28 March 2014

**LAND AT LOWFIELD ROAD, BOLTON-UPON-DEARNE
PLANNING APPLICATION BY GLEESON HOMES AND REGENERATION (APP. REF: 2013/0960)**

PROJECT	Lowfield Road, Bolton on Dearne		
TITLE	Proposed Footpath Through Hedge		
CLIENT	Gleeson Homes & Regeneration		
DATE	27 Mar 14	SCALE 1 : 100	SHEET A2
DRAWN	MP/bp	DRAWING NO	2292/2
CHECKED	MP	REVISION	-

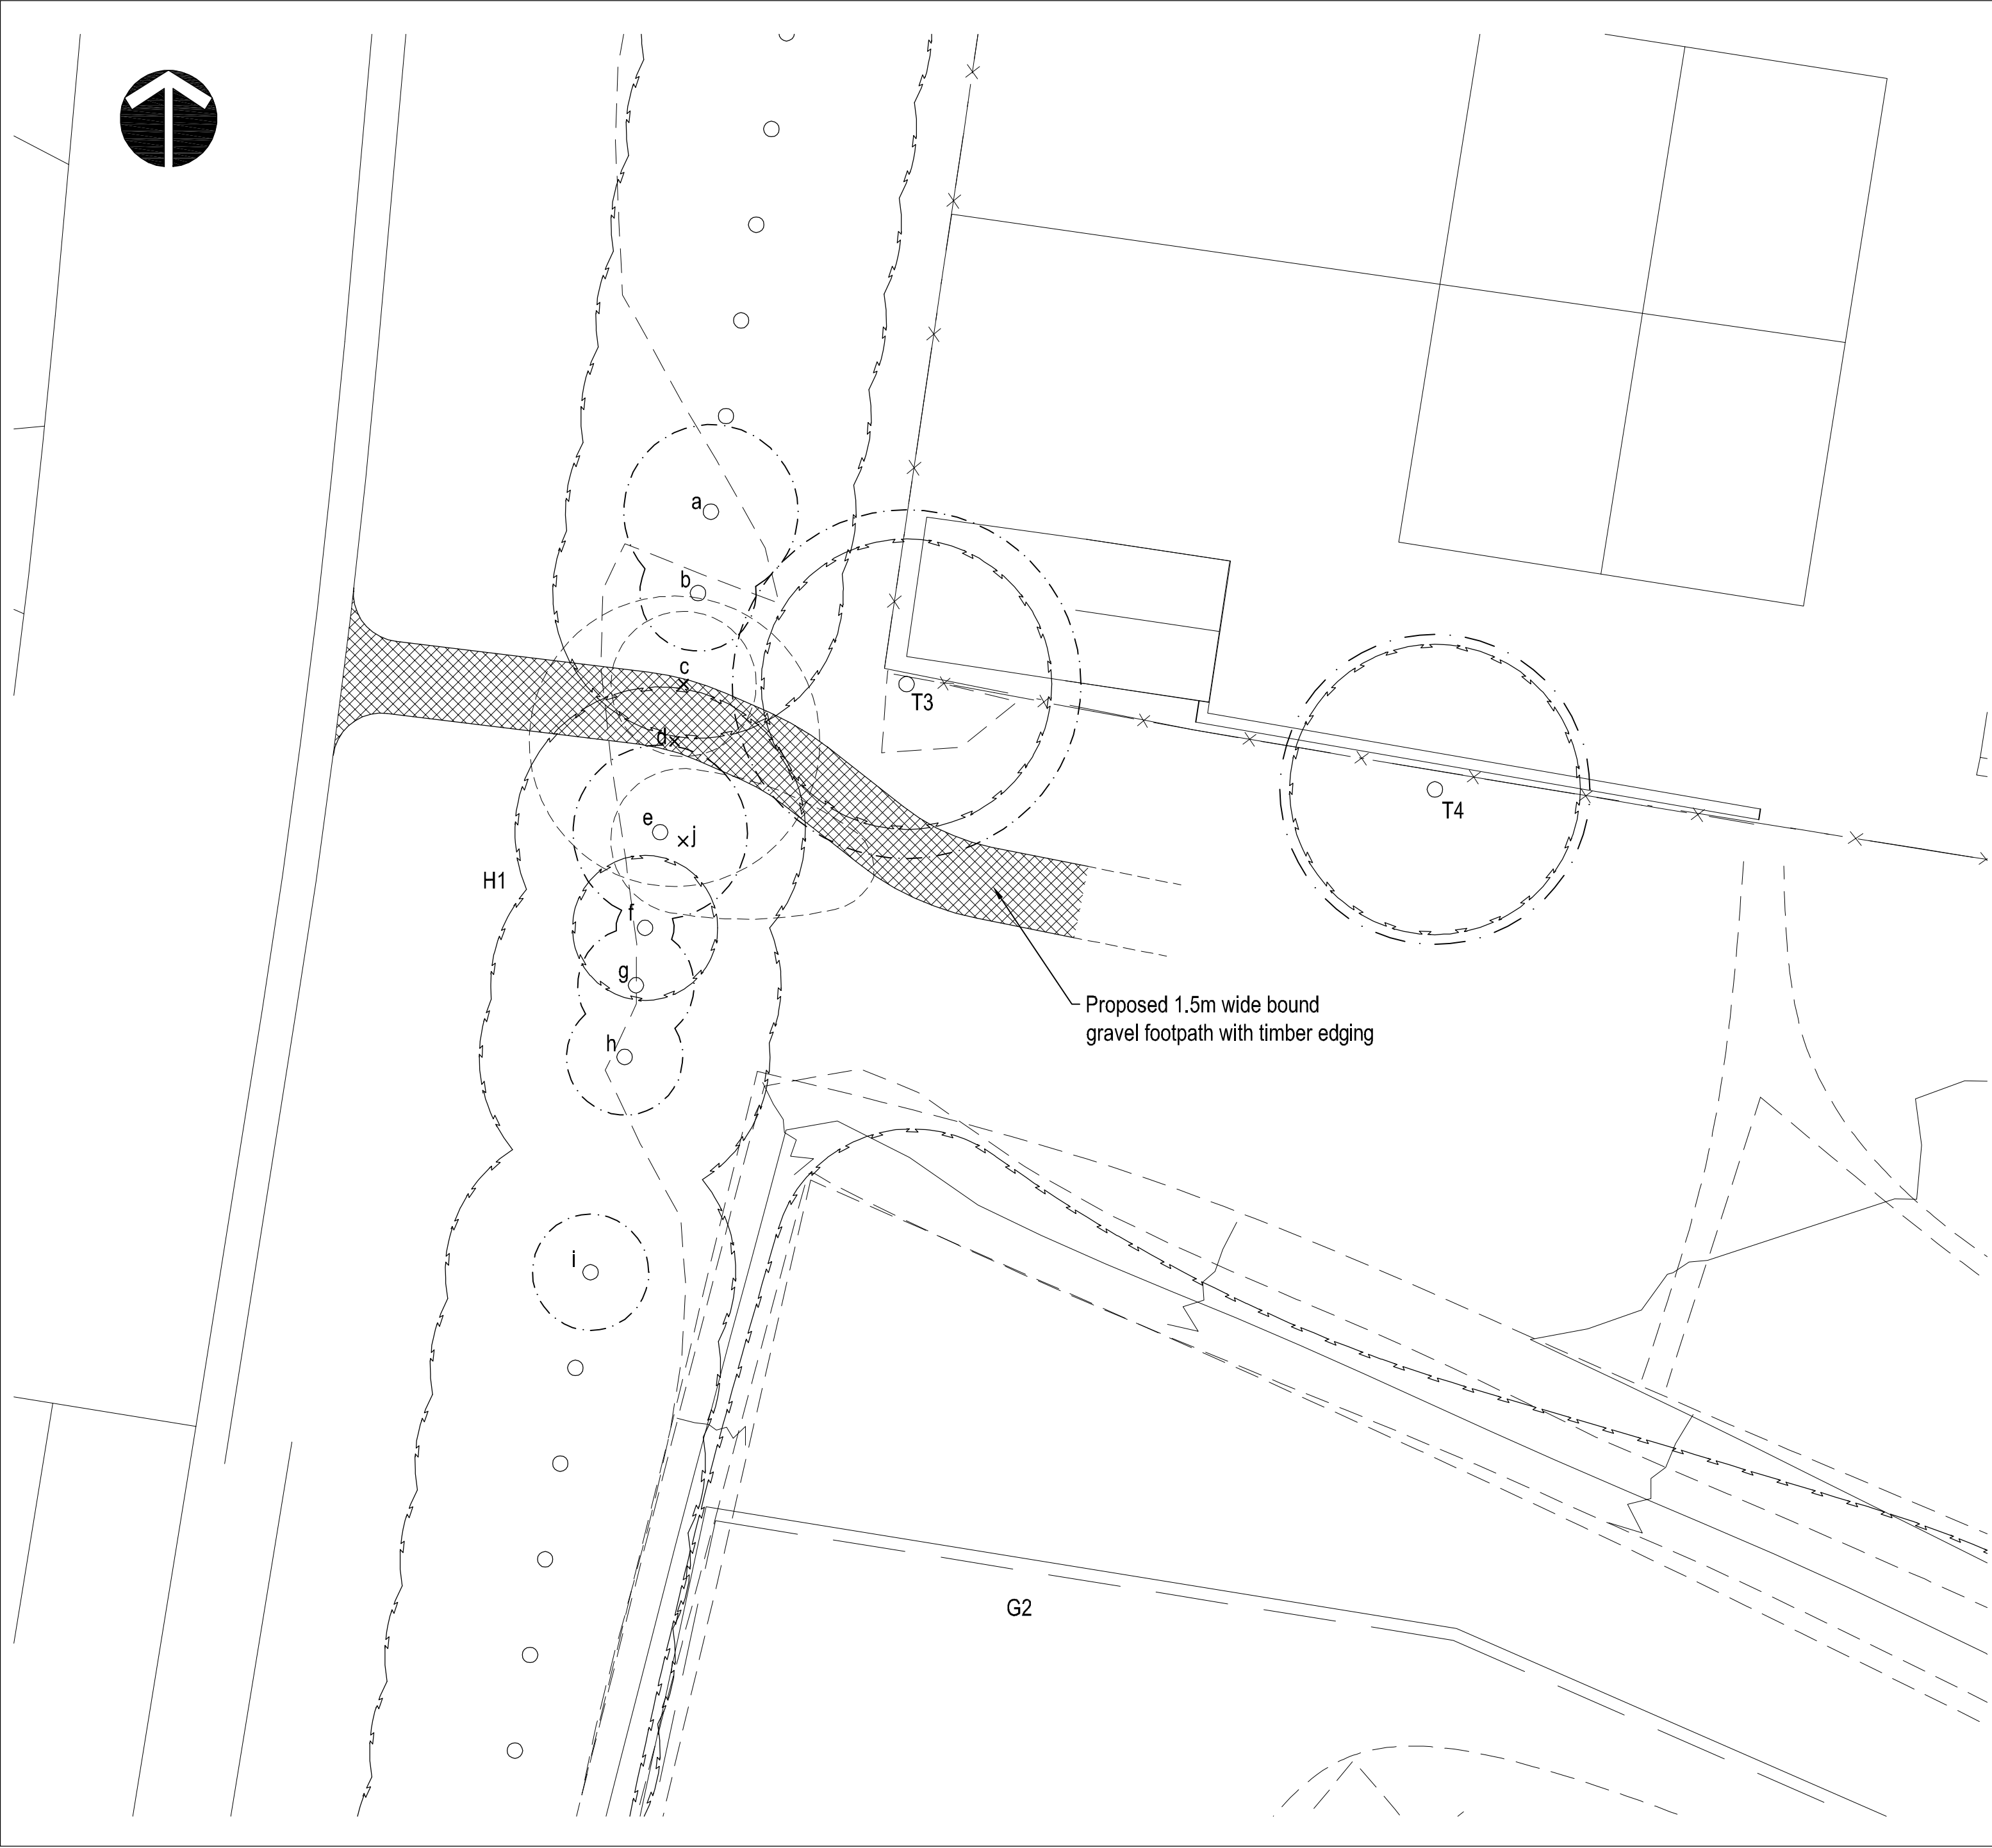
- (b) there is an existing informal footpath from Lowfield Meadows that runs to the east of the bund with planting. This route will be used to access the play area from the south. A gate to the play area will be provided where the informal footpath meets Lowfield Meadows to facilitate access from Lowfield Meadows to the north. There is a natural break in the hedgerow to the west of the play area. A new footpath link will be created to link the estate road to the play area so that it is easily accessible from the wider residential development to the west;

- (c) a specification has been prepared that demonstrates how this footpath link can be created without adversely affecting the hedgerow trees. It will not involve any excavation over the root ball of the trees, and will be constructed of porous material. The minor pruning works that would be advantageous to facilitate this access are also set out in this specification, and these will not impact upon the long-term health or viability of the trees.
